Michael Goddard
National Highways
Temple Quay House
2 The Square
Temple Quay
Bristol
BS1 6HA

22 October 2021

Response to Section 51 advice following issue of decision to accept the A417 Missing Link project for Examination

2.10 Habitats of Protected Species,  
Important Habitats or Other Diversity  
Features and Water Bodies in a  
River Basin Management Plan  
(Rev 1)

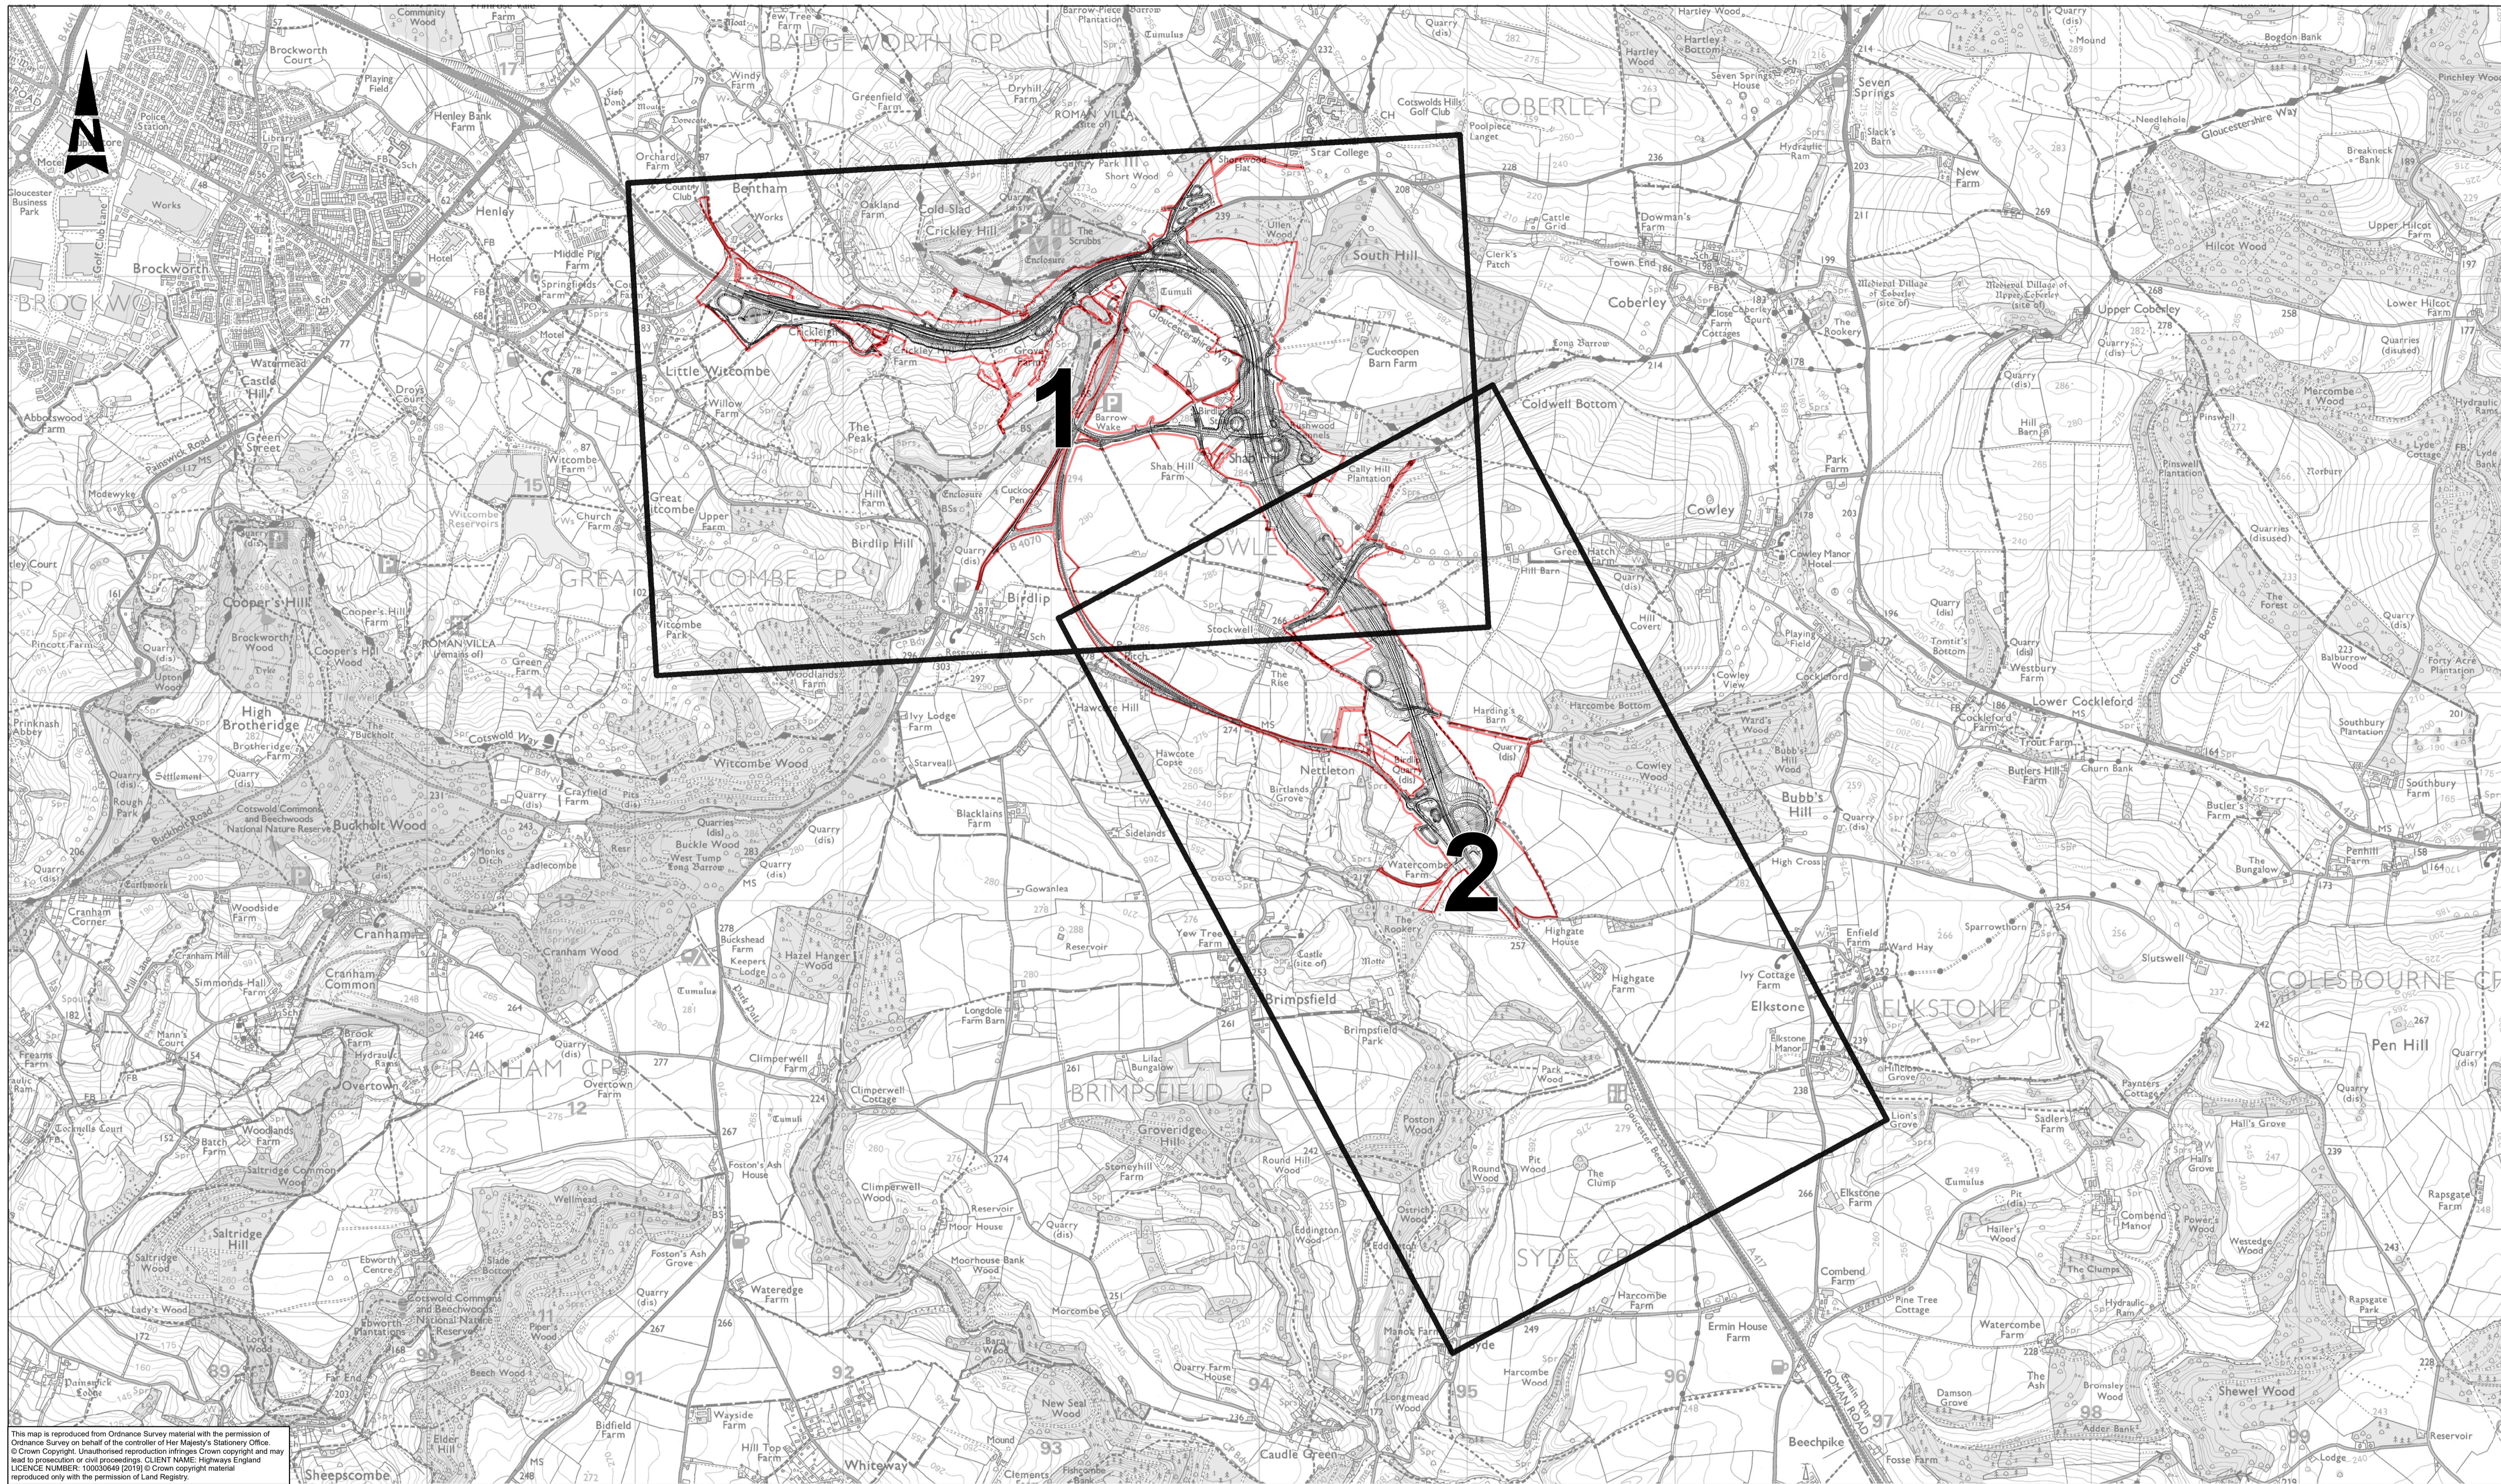
3. Volume 2 Plans, Drawings and Sections (Docs 2.2 to 2.8 and 2.10 to 2.13)	The main Key Plans do not include the proposed highways layout. The inclusion of the same would assist the future Examination by making it easier to identify the required sheet number.	The main Key Plans have been updated to include the proposed highways, drainage and structures layout .

The main Key Plans have been updated to include the proposed highways, drainage and structures layout in response to Section 51 Advice. The following plans have been updated and are-submitted alongside this letter:
